OFFICIAL NOTICE OF DECISION

CITY OF ALBUQUERQUE
PLANNING DEPARTMENT
DEVELOPMENT REVIEW BOARD

- 1. Project # 1003216**
04DRB-00094 Major-Vacation of Public Easements
04DRB-00093 Minor-Prelim&Final Plat Approval

SURVEYS SOUTHWEST LTD agent(s) for STERLING CAPITAL DEVELOPMENT LLC request(s) the above action(s) for all or a portion of Lot(s) 12-C and remainder of Lot 12, Block(s) 141, **SNOW HEIGHTS ADDITION**, zoned C-2, located on WYOMING BLVD NE, between NORTHEASTERN BLVD NE and INDIAN SCHOOL RD NE containing approximately 2 acre(s). (H-20)

PLAT OF
 LOT 12-C-1, BLOCK 141
 SNOW HEIGHTS ADDITION
 SECTION 8, T. 10 N., R. 4 E., N.M.P.M.
 CITY OF ALBUQUERQUE
 BERNALILLO COUNTY, NEW MEXICO
 JANUARY 2004
 SHEET 2 OF 2

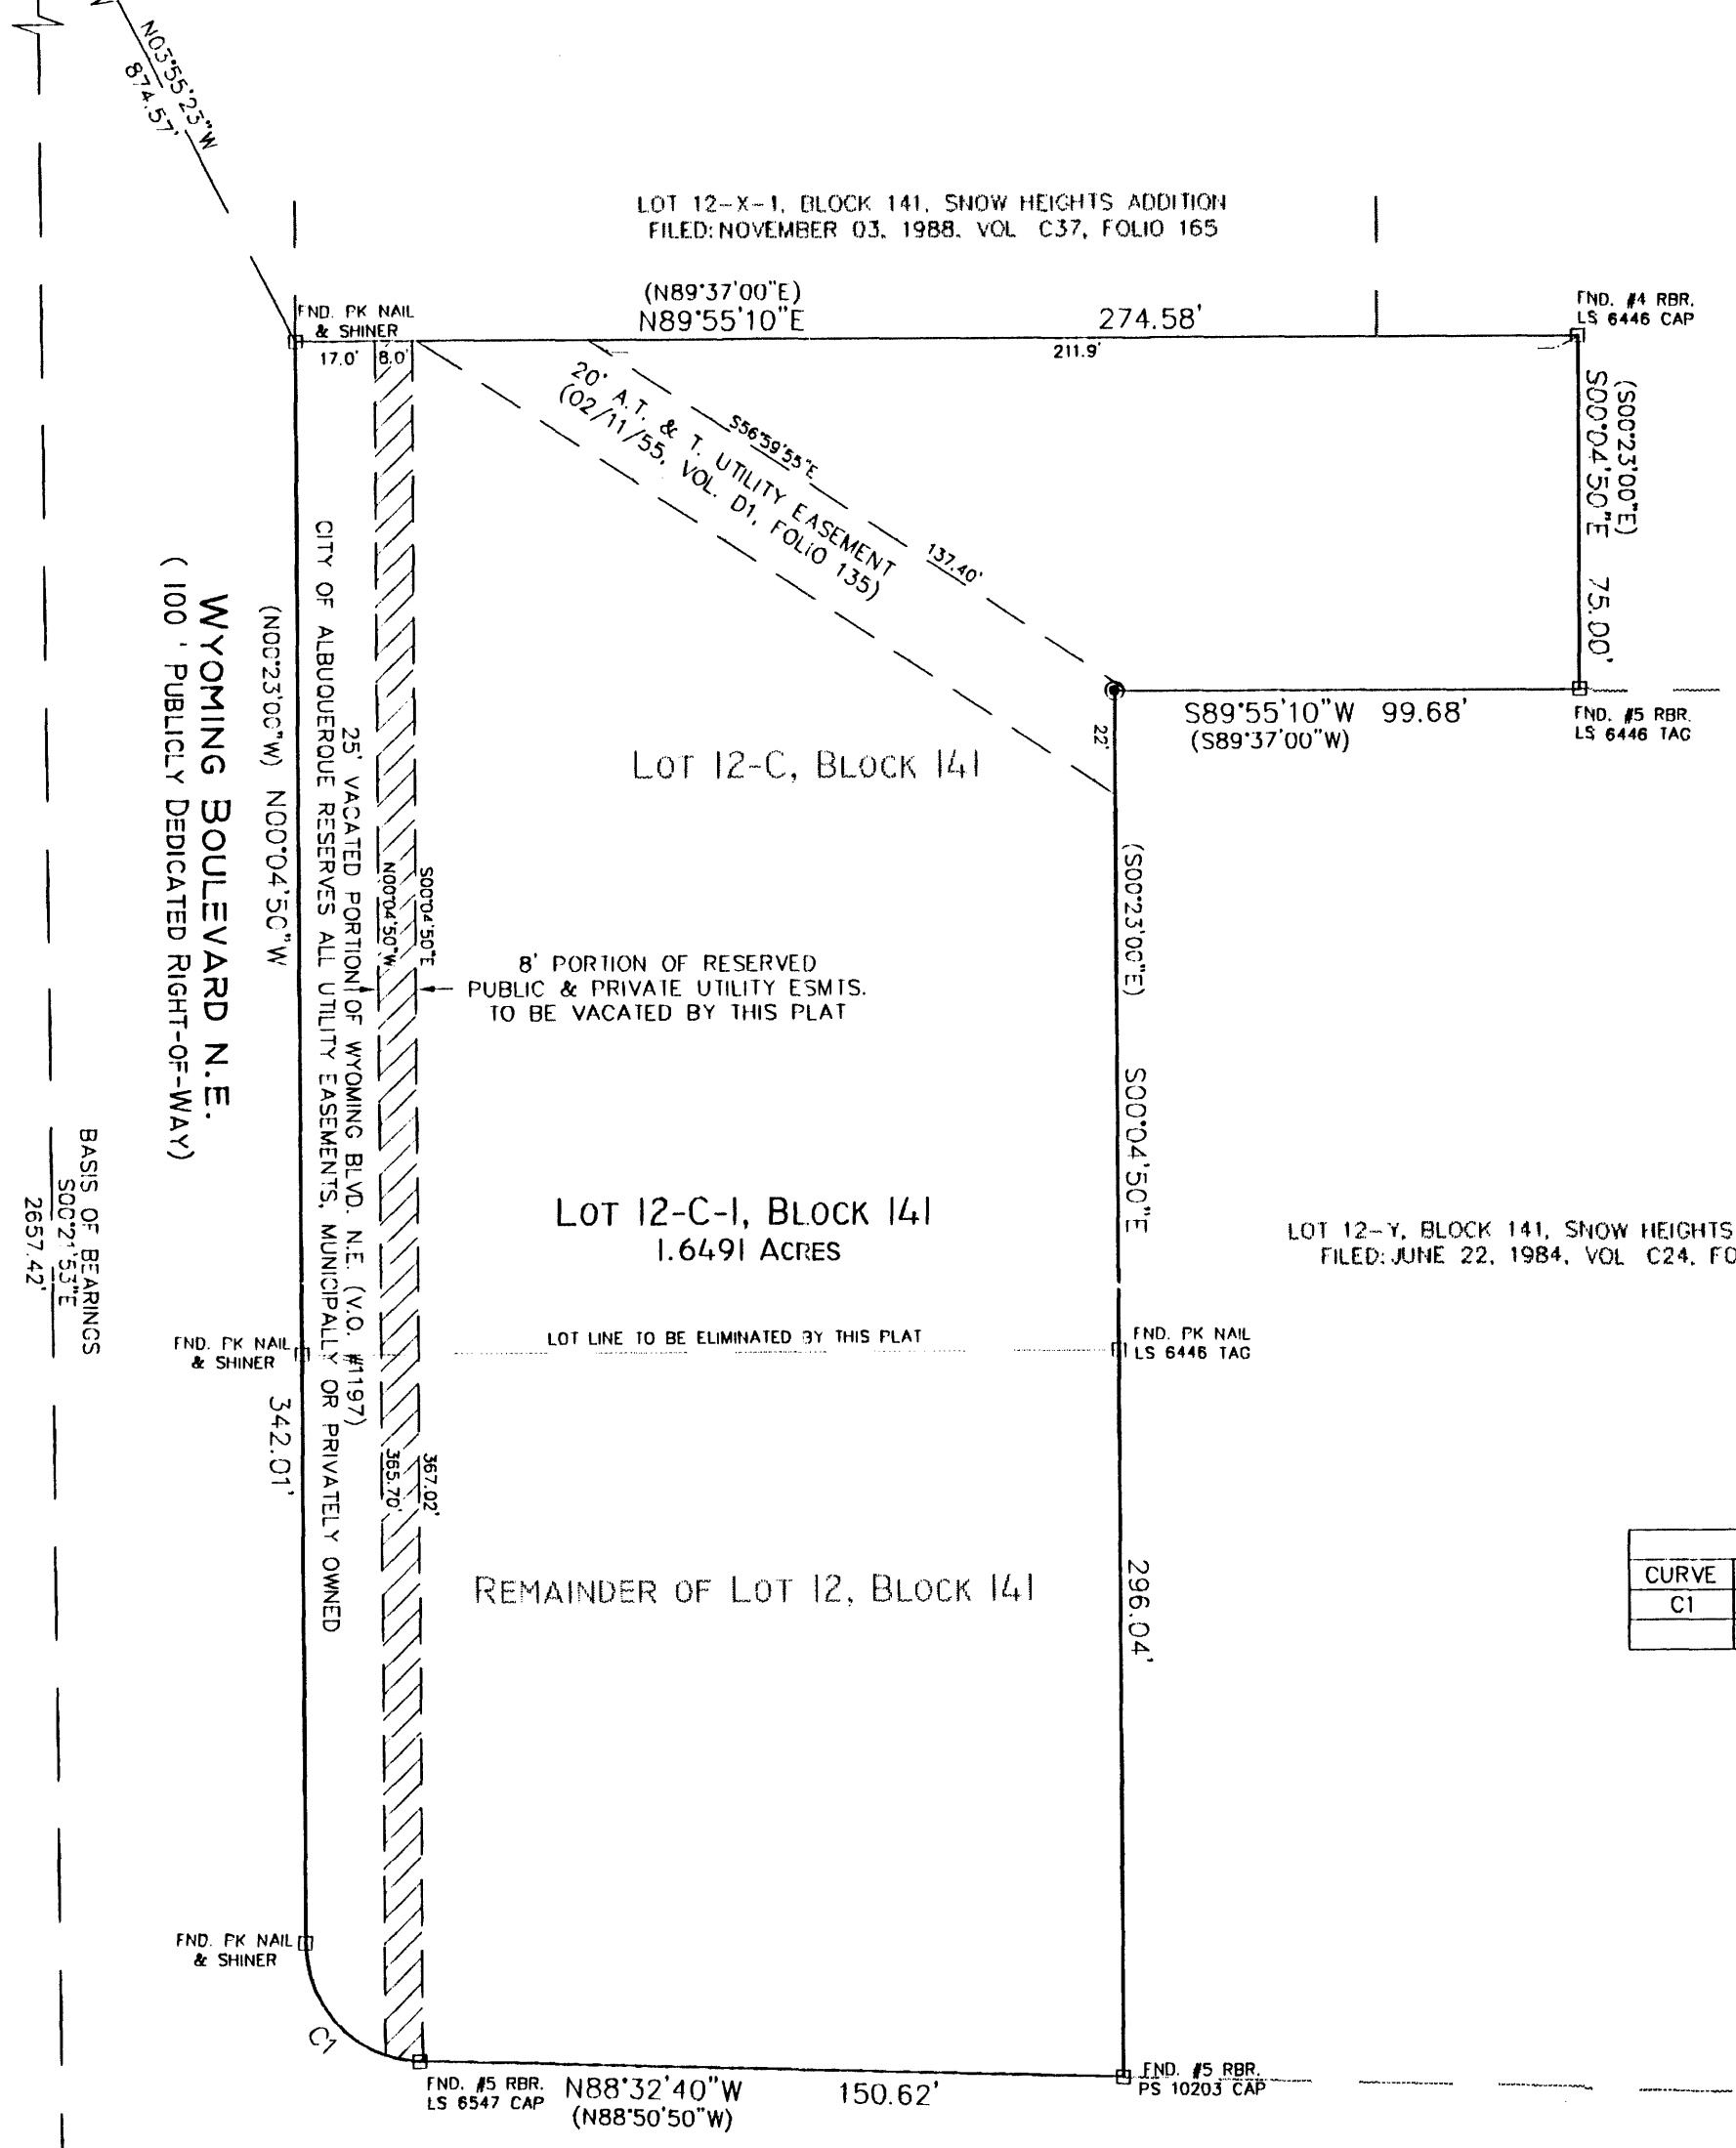
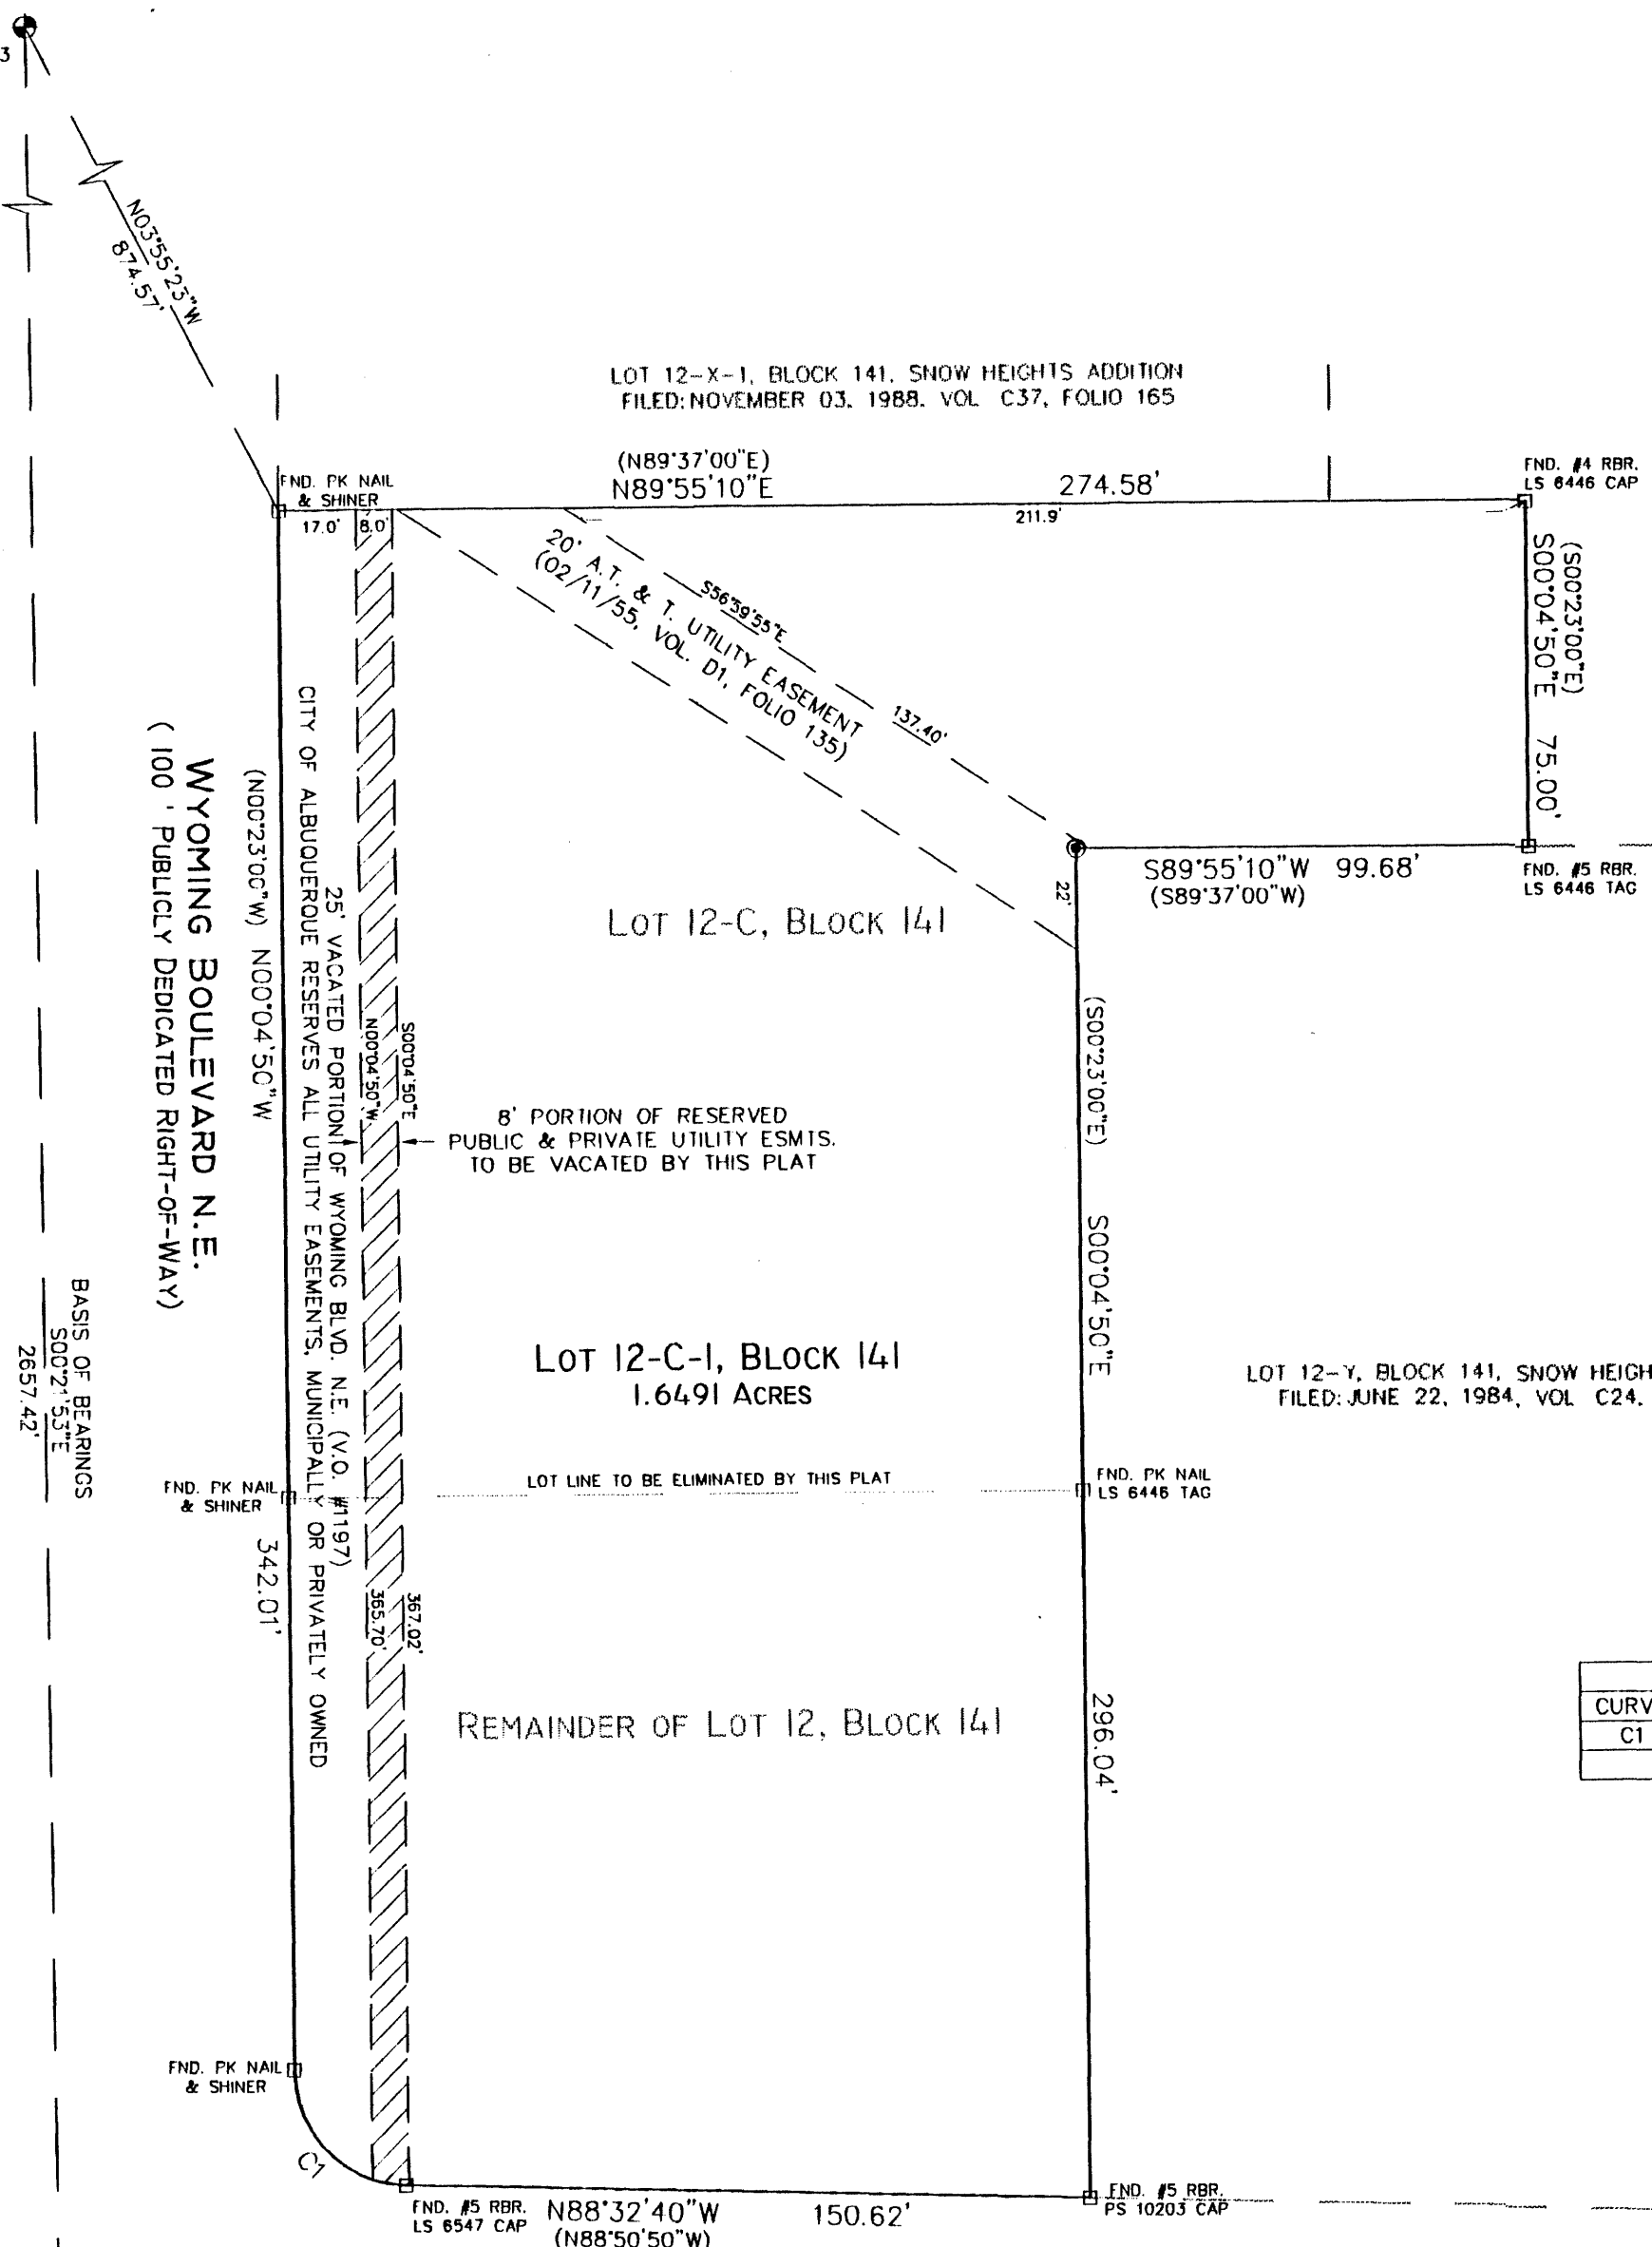
- 1) The radius for C-1 shall be modified to skirt the power pole.
